From: frederickelder@aol.com
To: [Adil R](#)
Cc: [Ron Hensley](#); [Shakeel Rizvi](#); [Wolfley, Jolene](#); [Roddenbeck, Jay B.](#); [Ray Schena](#); [Bryan Handing](#); [Lynn Handing](#); [Frederick Elder](#); [Nichole Donahue](#); sceferino@yahoo.com; [Sal Narayan](#); [KATHI COWHAM](#); laurajane0125@gmail.com; [Danny Mitchell](#); [Vidya S](#)
Subject: Re: PR-2022-006568 Valentino Subdivision Supplemental Submittal
Date: Monday, March 11, 2024 10:49:43 AM

Good morning, Mr. Rizvi, -- I have been looking over the new submission and am confused by several of the new details particularly regarding the safety fences, terrace access, and terrace landscaping.

DRAWING NO:
LS-101

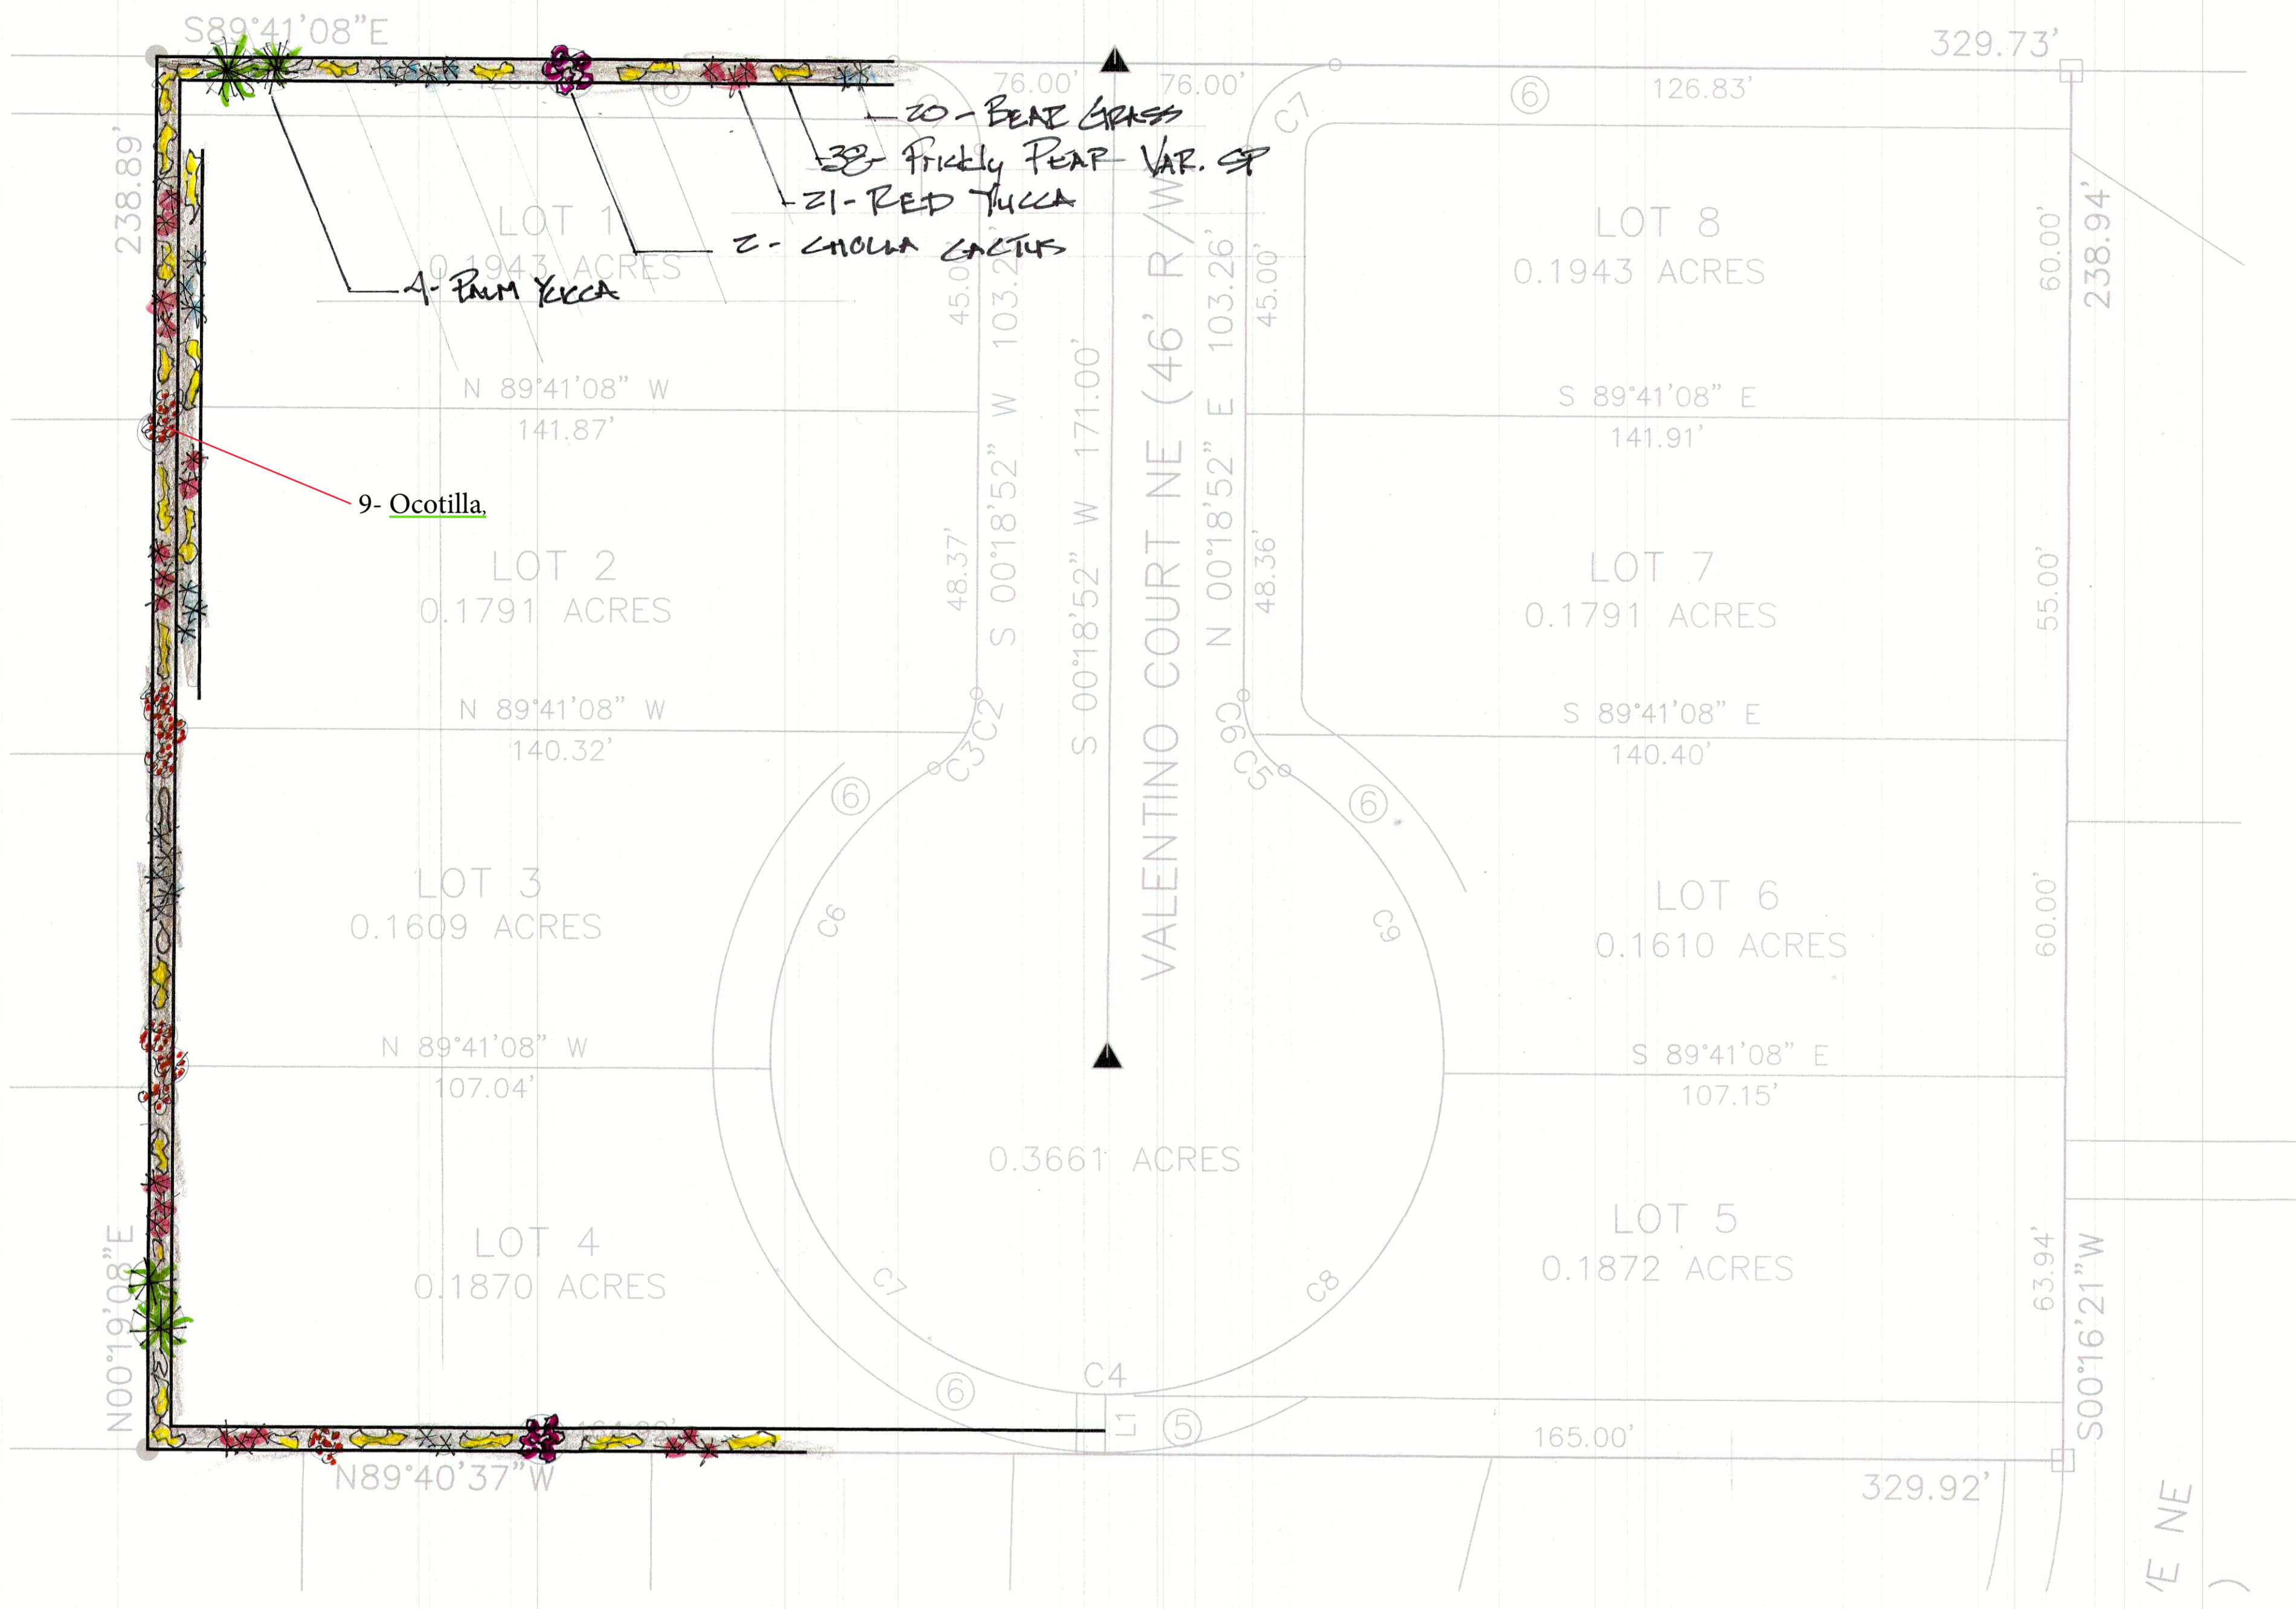
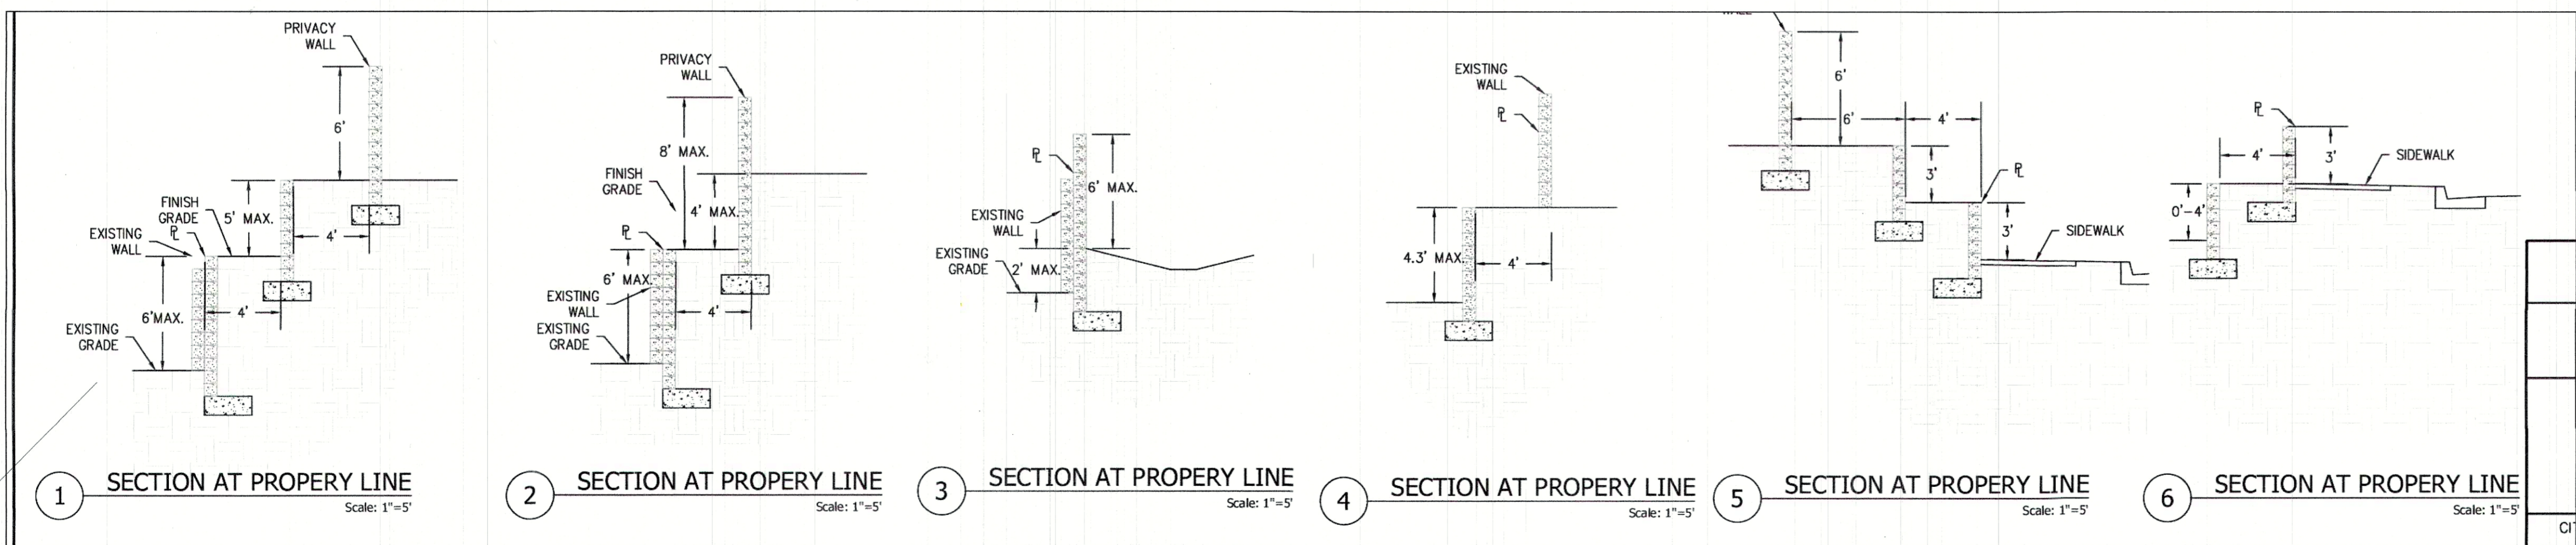
Regarding the terraces, landscaping, and maintenance: The new landscaping diagram shows a relatively dense planting of some formidably thorny vegetation along the terraces. The proposed CC&R will require that, "Owners of Lots 1 through 4 shall be responsible for maintaining their respective "Landscape Terrace" along their backyards."

Your new landscape schematic indicates that these plants will be hand-watered. There will be no irrigation provided to the terraces. The reason, as stated on the landscape schematic is, "...due to the instability of the soils and the danger of wall failure by the addition of irrigation water into the substrate..." Since there is no irrigation, how do you propose that these owners water the terraces, particularly on the west side, and fulfill their maintenance obligation? Are you thinking that they will be watering them by running a hose over their privacy walls and all the way down to the lower terrace? Perhaps by bucket? We have discussed the need for gates in these privacy walls to allow access to the lower terrace, but I think that may have been voted down at the Zoom meeting. It would appear that the proposed development will be creating some unreasonable if not impossible terrace maintenance problems for new residents on the west side. How will you resolve that?

As an aside, in the event that leaf blowers are used to help maintain the terraces, it is very likely that all that accumulated dust and debris will be removed to the backyards

1 SECTION AT PROPERTY LINE Scale: 1"=5'
 2 SECTION AT PROPERTY LINE Scale: 1"=5'
 3 SECTION AT PROPERTY LINE Scale: 1"=5'
 4 SECTION AT PROPERTY LINE Scale: 1"=5'
 5 SECTION AT PROPERTY LINE Scale: 1"=5'
 6 SECTION AT PROPERTY LINE Scale: 1"=5'

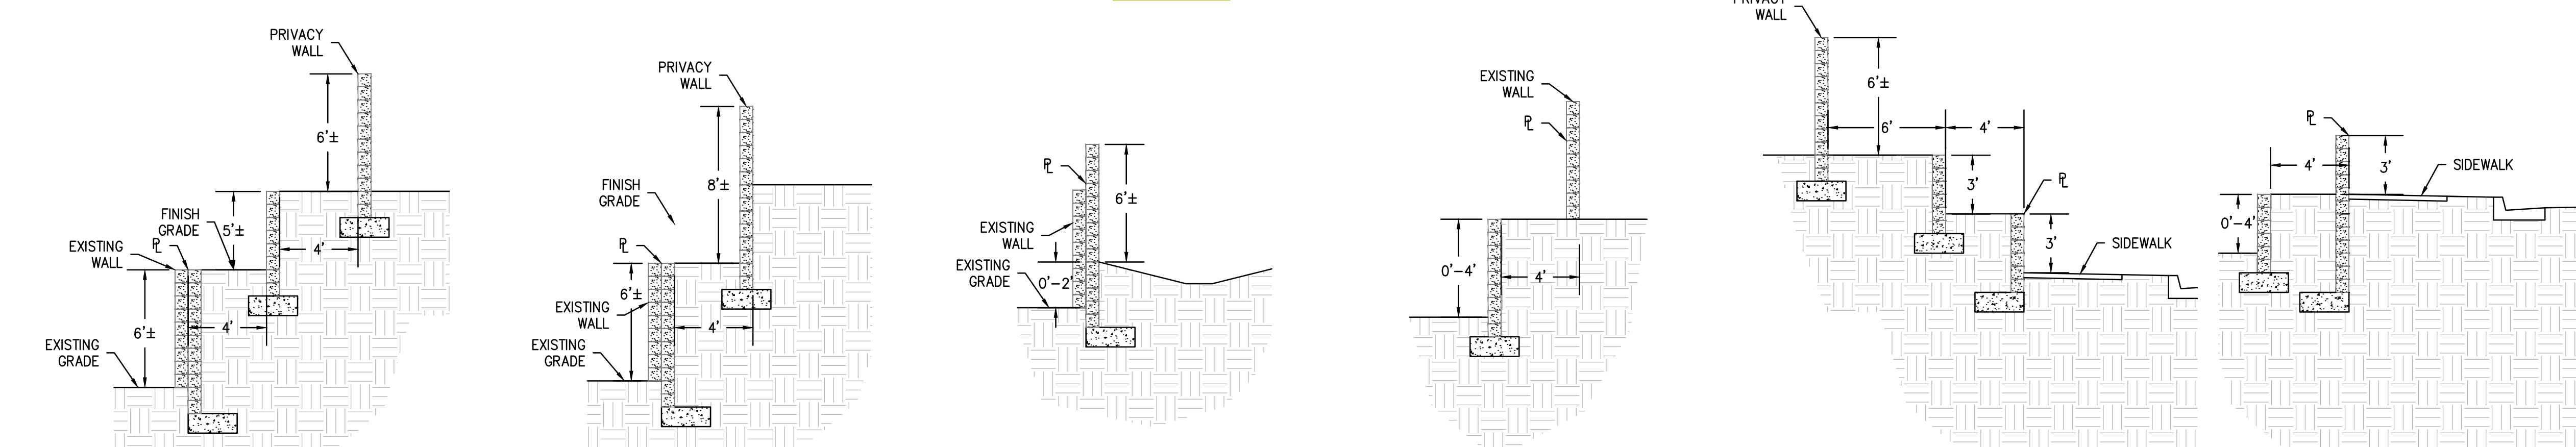
Regarding the safety fences: My reading of your fence and wall diagrams suggests to me that the safety fence is attached to the existing homeowner's walls. That seems unlikely to me, but since modification of existing walls on the east side has been discussed, I think this needs to be clarified.

Simply stated, mounting the security fences to the existing walls is not acceptable. Doing so will not ensure uniform height for the fences, and it cannot ensure a stable footing for the fences. The security fences need to be placed atop the lower retaining walls which are shown to be higher than the existing walls in all of your representations of the west and southwest sides of the proposed development. This needs to be clearly stated.

Additionally, the security fence construction you are describing with tubing of $\frac{3}{4}$ inch rails and $\frac{1}{2}$ inch pickets seems significantly less substantial than those examples presented to the homeowners in the Zoom meeting of March 2, 2024. You should upgrade the plan to a more substantial security fence that is more in line with what you showed us at the meeting.
